Our Ref: RVBC-MH-APP-002 (2)

Date: 26/January/2022

**PLANNING APPLICATION Ref: 3/2021/0661 - Haweswater Aqueduct Resilience Programme  
Proposed Marl Hill Section (Ribble Valley Borough Council)**

**APPLICATION UPDATES**

Illustration 2: Indicative appearance and vertical elevations of temporary bridge structures

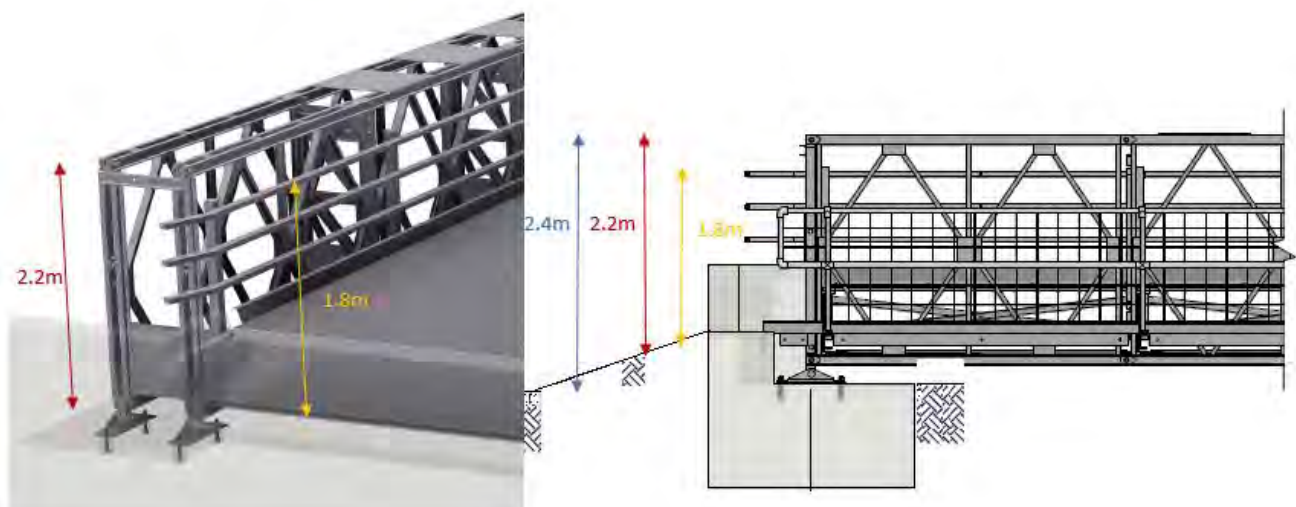
A series of minor alterations to the access track serving the core construction area at the Braddup Compound, off Slaidburn Road, are proposed and result in five minor amendments to the planning application boundary along the access track towards the main construction compound. These amendments are to allow the installation of five temporary bridge structures (commonly referred to as ‘Bailey bridges’) along the proposed access track (see updated construction phase drawings for their locations: RVBC-MH-APP-004-05\_03 and 04, and the updated connection phase drawings: RVBC-MH-APP-004-06\_03 and 04).

The purpose of the proposed temporary bridging structures is twofold:

- To span and protect a series of existing culverts through which field drains currently flow in a north-south direction below the existing road
- To protect the root zones of Grade A trees situated adjacent to the track.

Illustration 1 shows the typical vertical elevations of the temporary bridge structures would be of steel lattice construction and rectangular in shape. Concrete footings for the temporary bridges would be constructed in excavations approximately 1.5 m below existing ground level.

SCALE 1:2,000	SHEET SIZE A3
DRAWING NUMBER RVBC-MH-FIG-006-005-AD1	REVISION 0

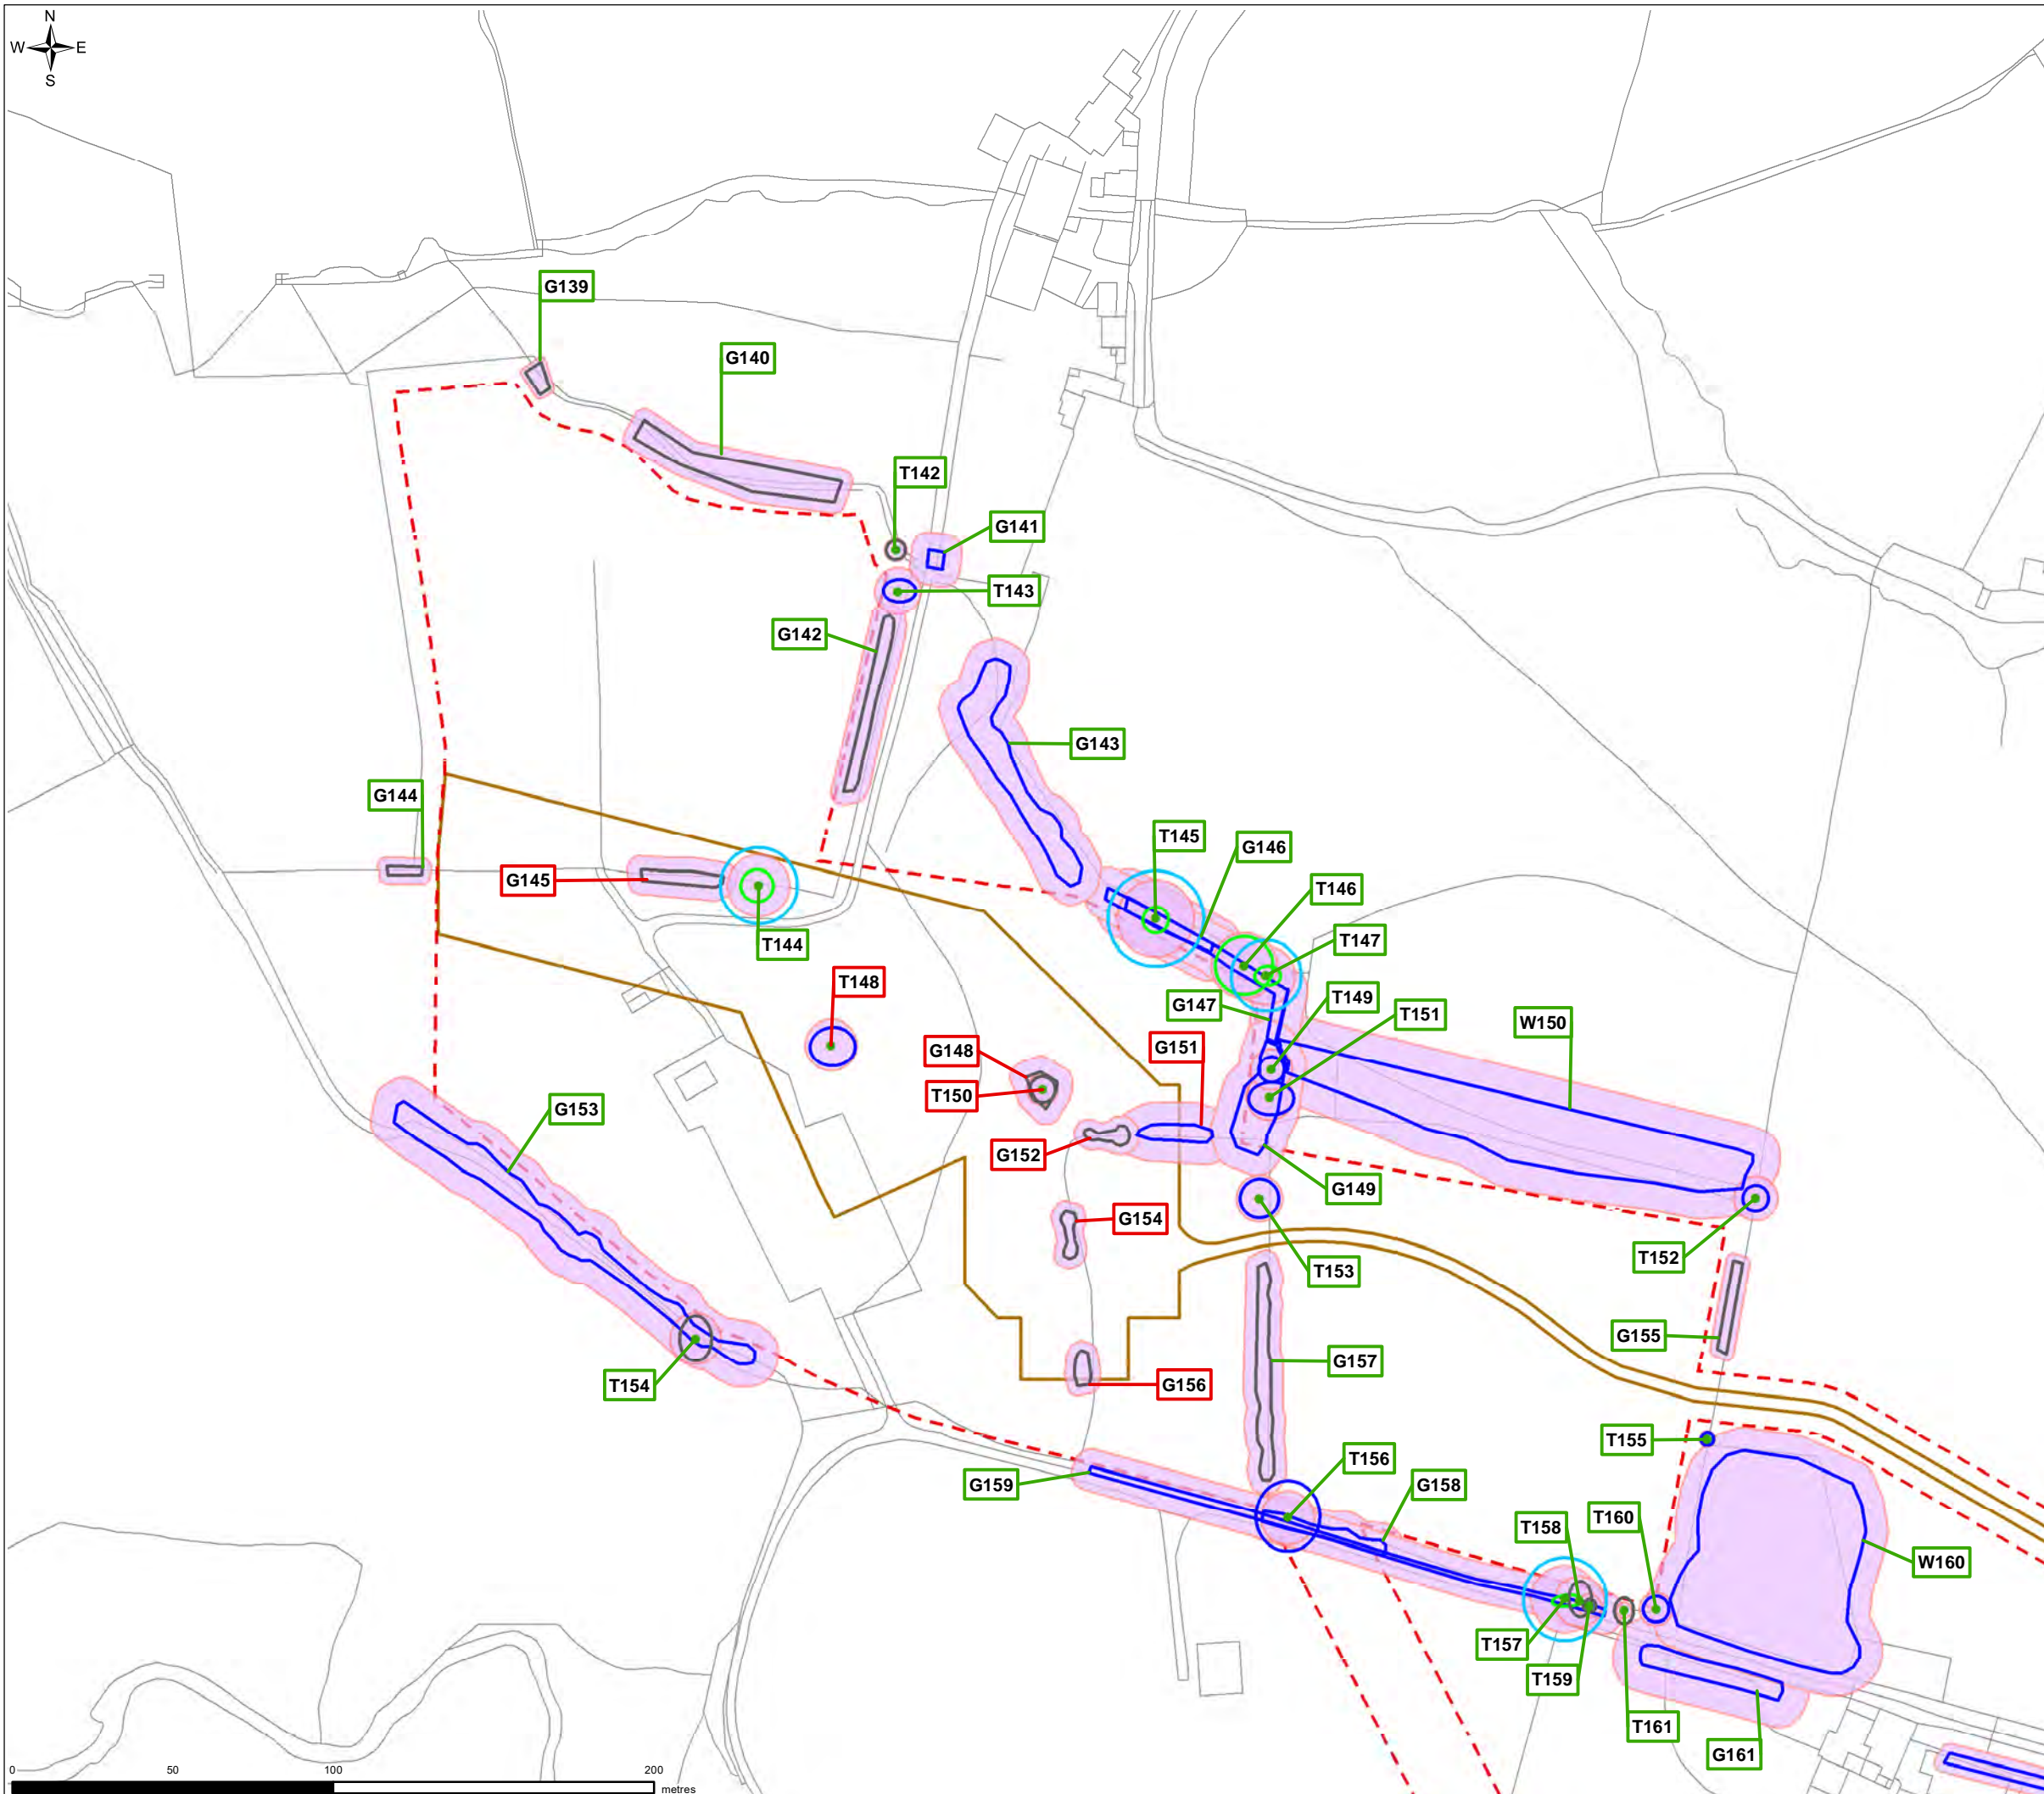
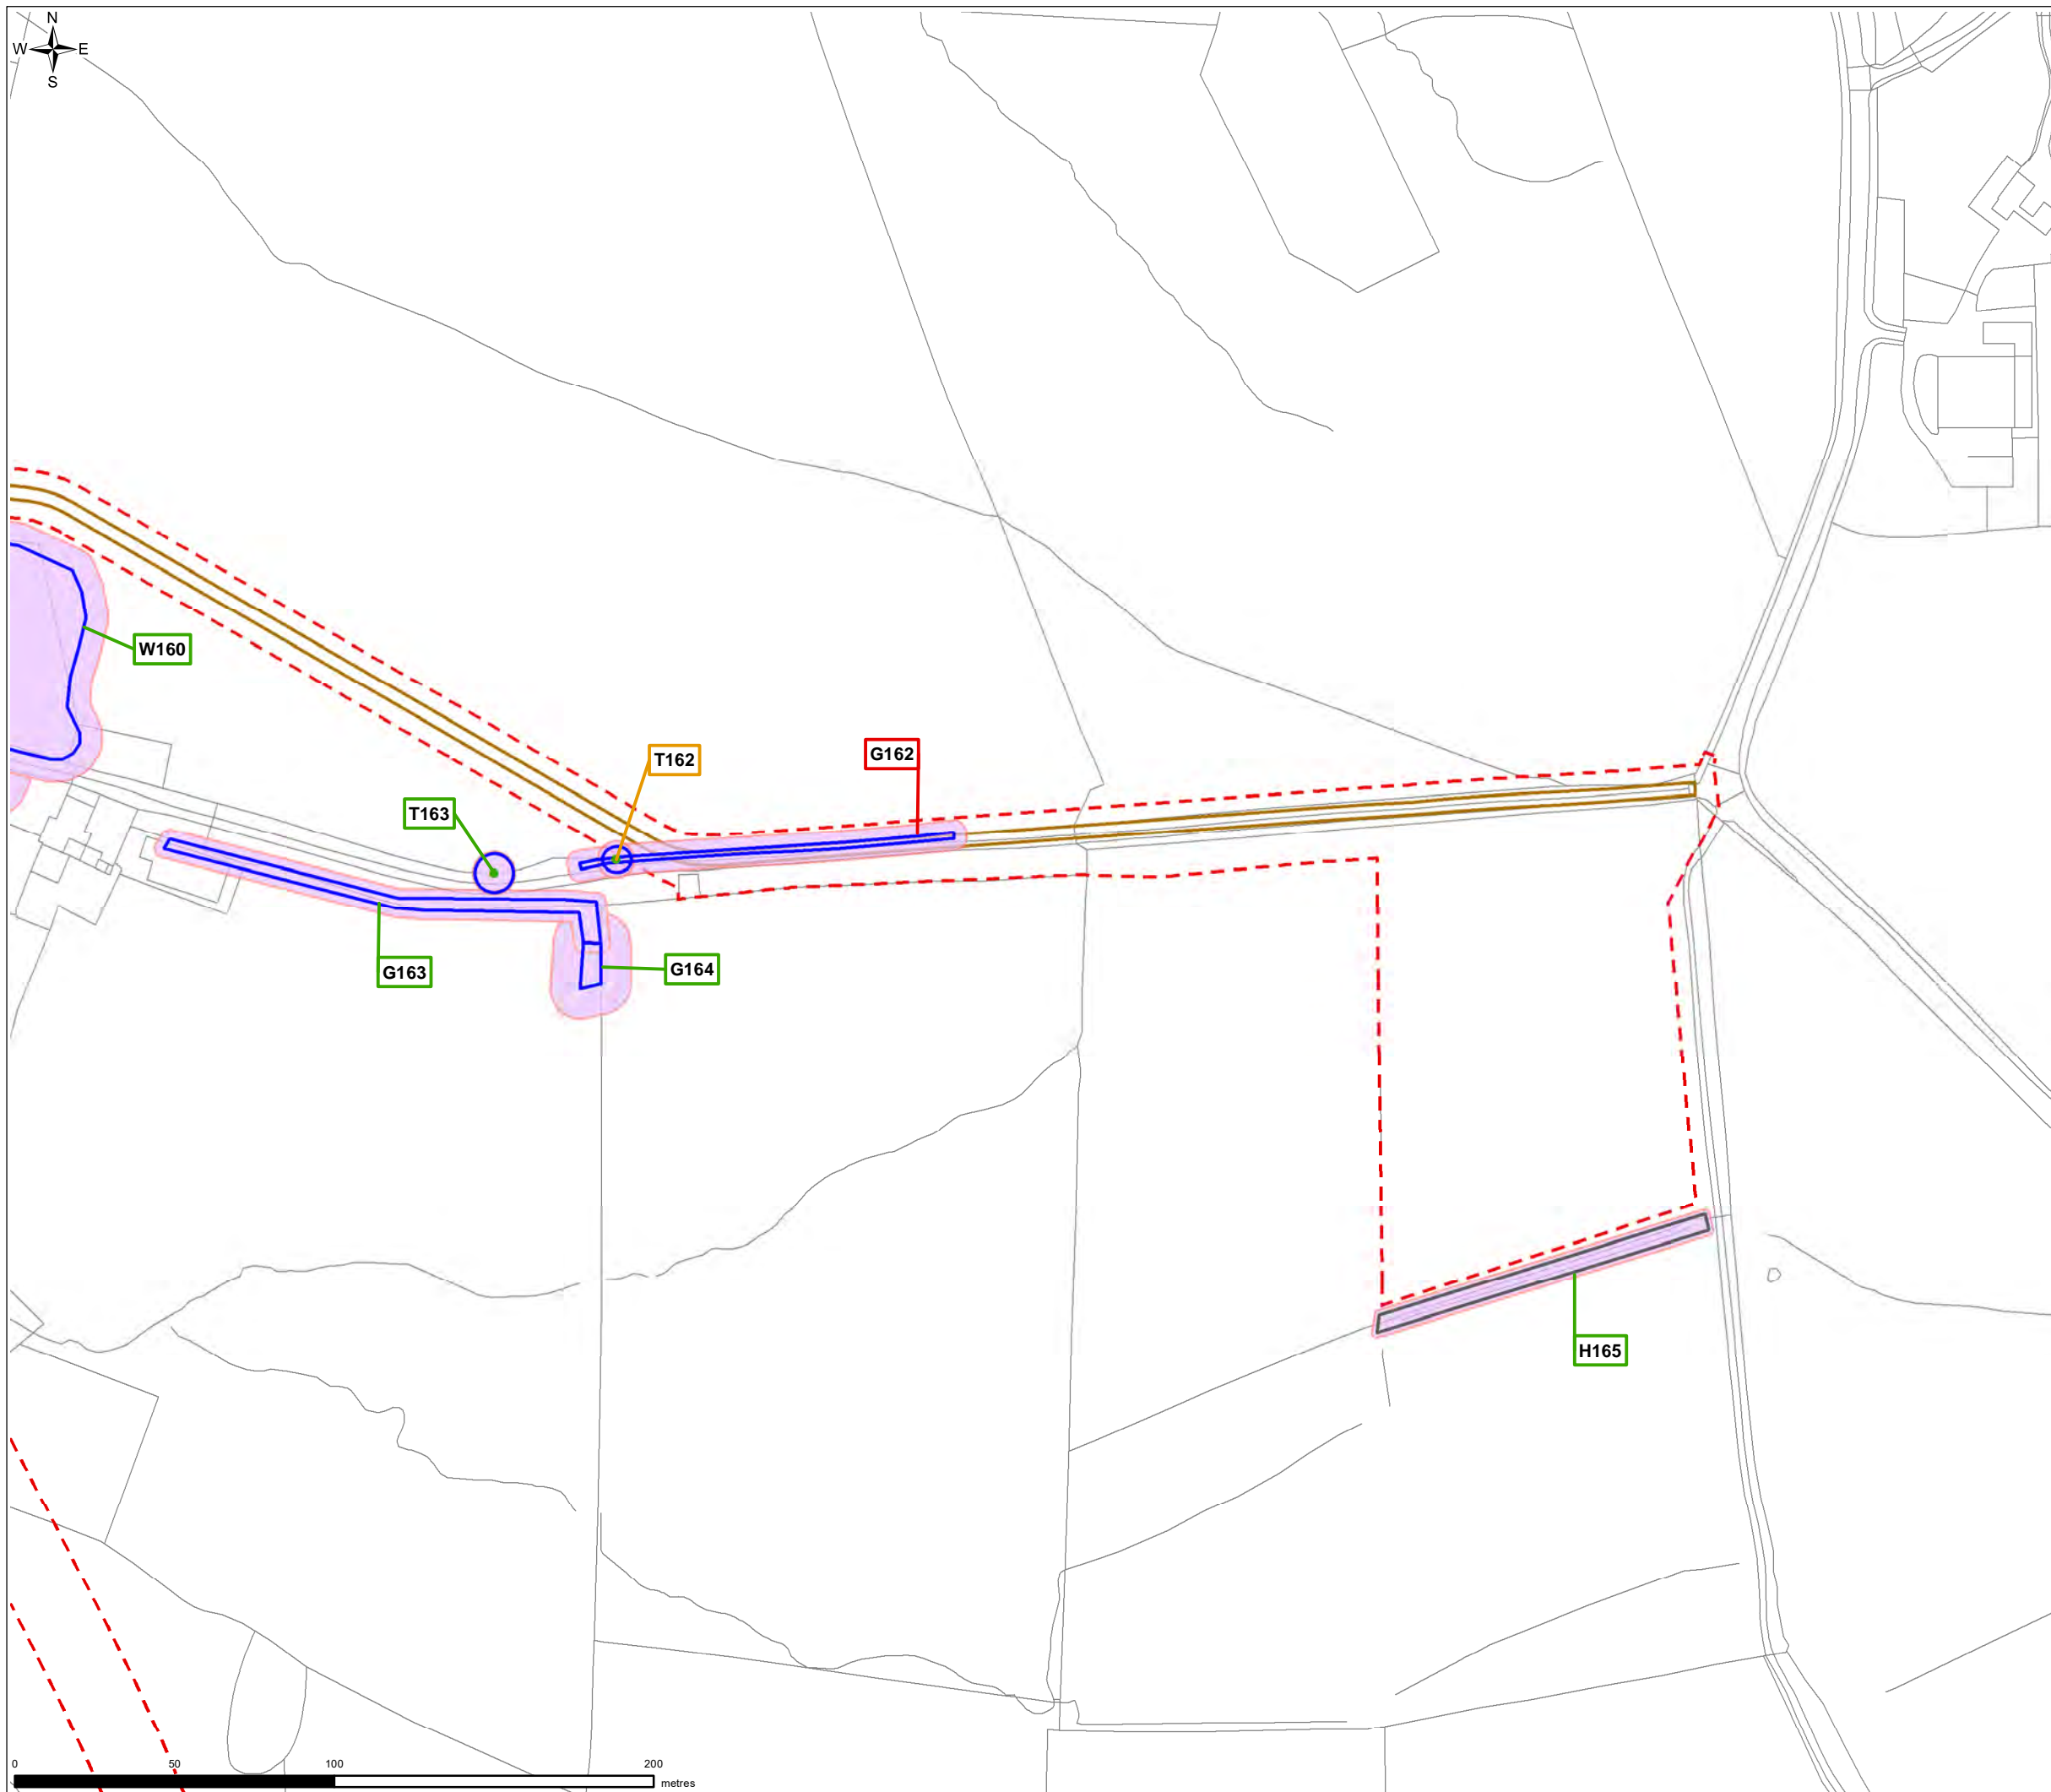
Further design refinement has led to the avoidance of some previously proposed affected trees within the construction compounds and these are reflected on the updated Series 3 - Site Layout Plans.
